# KITTITAS COUNTY

## DEPARTMENT OF PUBLIC WORKS

**TO:** All Staff  
**FROM:** Public Works Plan Review Team  
**DATE:** October 12<sup>th</sup>, 2023  
**SUBJECT:** Public Works Comments: BL-23-00024

DATE: 2023-08-22 SHEET 1 OF 1

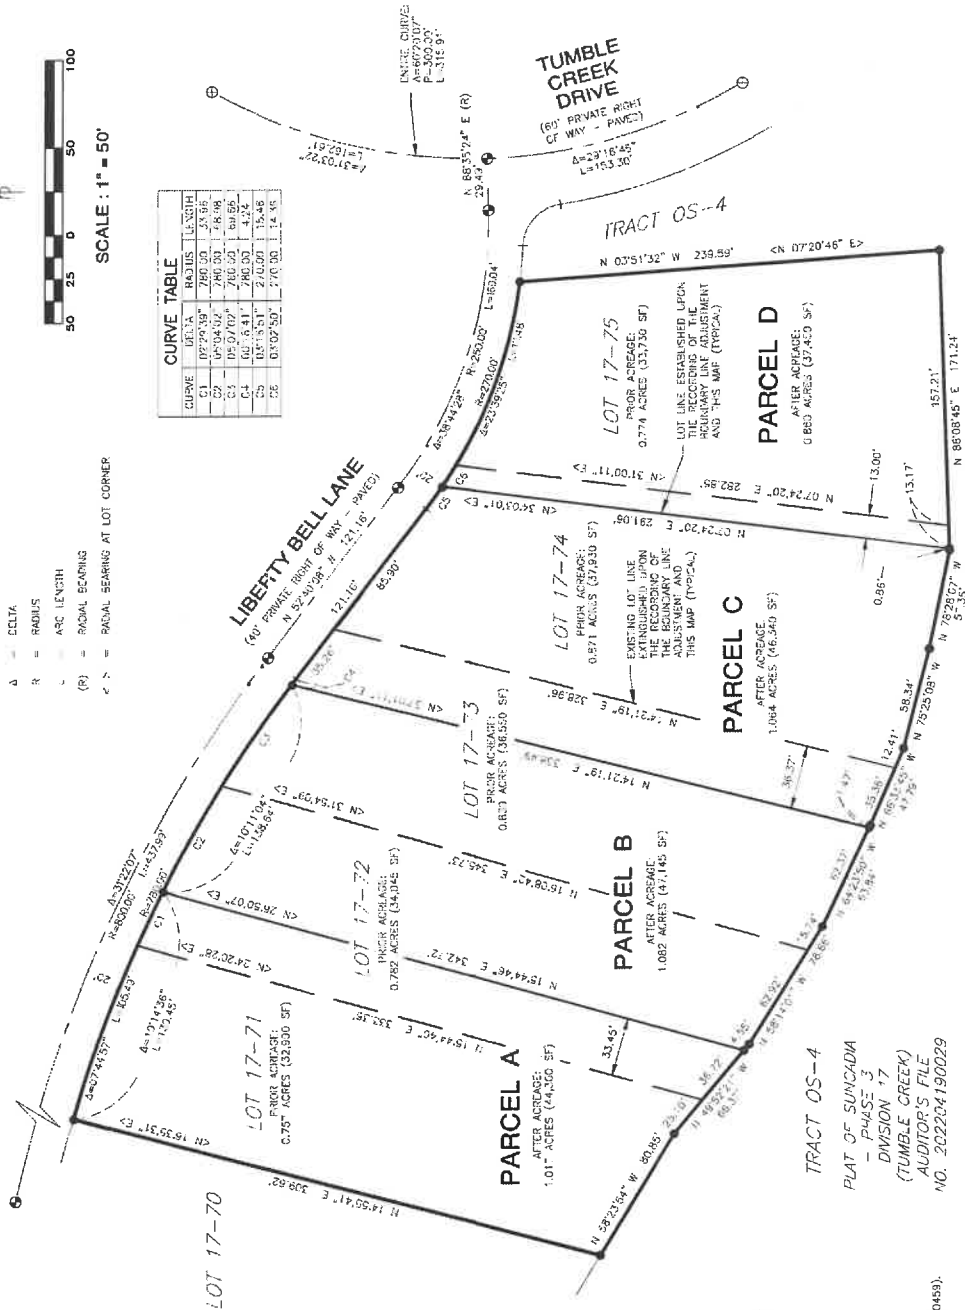
<b>ACCESS</b>	No comments (JS)
<b>ENGINEERING</b>	No comments (JF)
<b>SURVEY</b>	<ol style="list-style-type: none"><li>1. Revise Note 3 to include reference to application BL-23-00024.</li><li>2. The legend shows centerline monuments to be set after construction. If these monuments have still not been set, please include reference ties to existing survey control network, suitable for retracement.</li></ol> <p>OF NOTE Lot closures were not reviewed as part of this survey review. Given the simple nature of the BLA, this was not required. (JT)</p>
<b>TRANSPORTATION CONCURRENCY</b>	No transportation concurrency application required for this project. (KAH)
<b>FLOOD &amp; WATER MITIGATION/ METERING</b>	No comments. (SC)
